CITY OF MERCER ISLAND

October 26, 2017

RE: CAO17-007 (Critical Area Determination for 4634 E Mercer Way)

**SITE SLOPE CALCULATION**

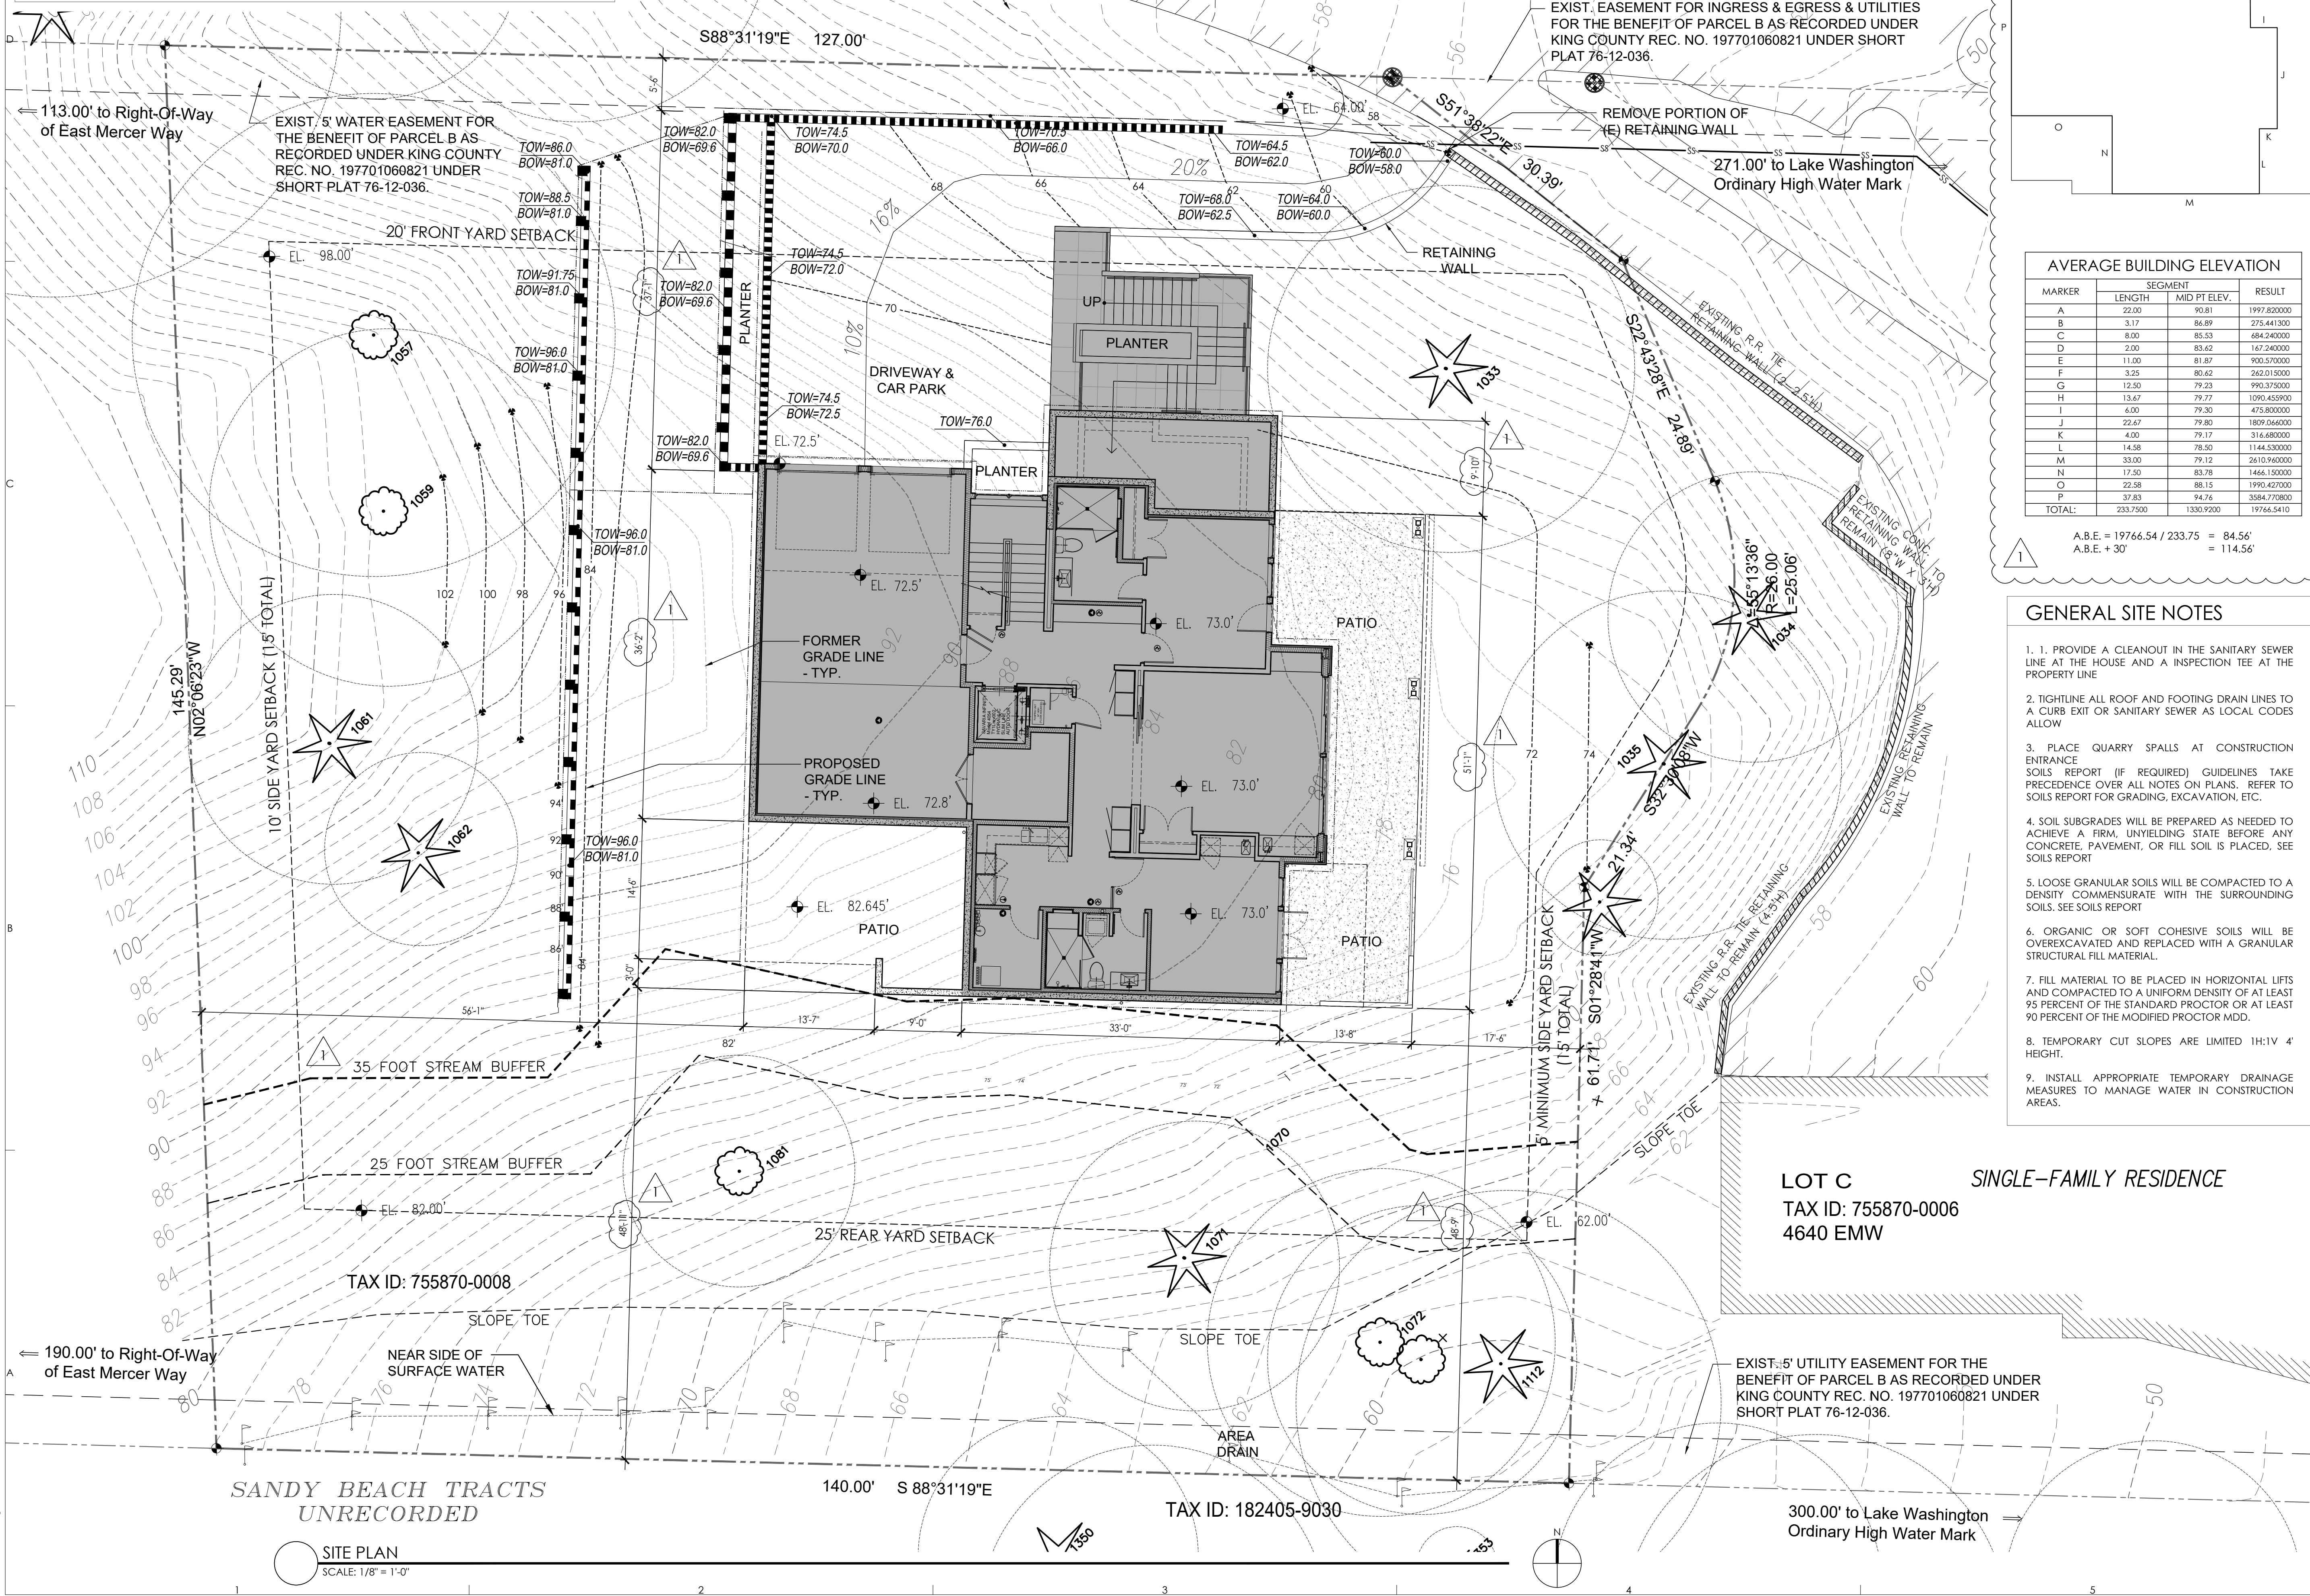
2. Sheet A1.01 shows watercourse delineation flags. Sheet 3 of 6 of the civil plan set submitted for permit 1507-166REV proposes drainage infrastructure in what appears to be the same area as the watercourse (in the southeast corner of the site). In your resubmittal, please provide a sheet showing the location of the proposed drainage infrastructure in relation to the delineated watercourse.

- a. Based upon a review of the current plan set, it appears that work is proposed within the watercourse channel (on lands covered by water) and consequently a SEPA review is required. Please either apply for a SEPA review, or modify the proposed design to avoid work on lands covered by water.

- b. Note that if development is proposed within the watercourse or associated buffer, the scope of review under CAO 17-007 will need to be expanded to include review the proposed scope of work for compliance with MICC 19.07.030(7). Please either modify

the proposed design to avoid work within the watercourse buffer, or provide a critical areas study that addresses the proposed work within the watercourse buffer (e.g. identifies the scope of the impact, addresses minimizing impacts, and proposed mitigation).
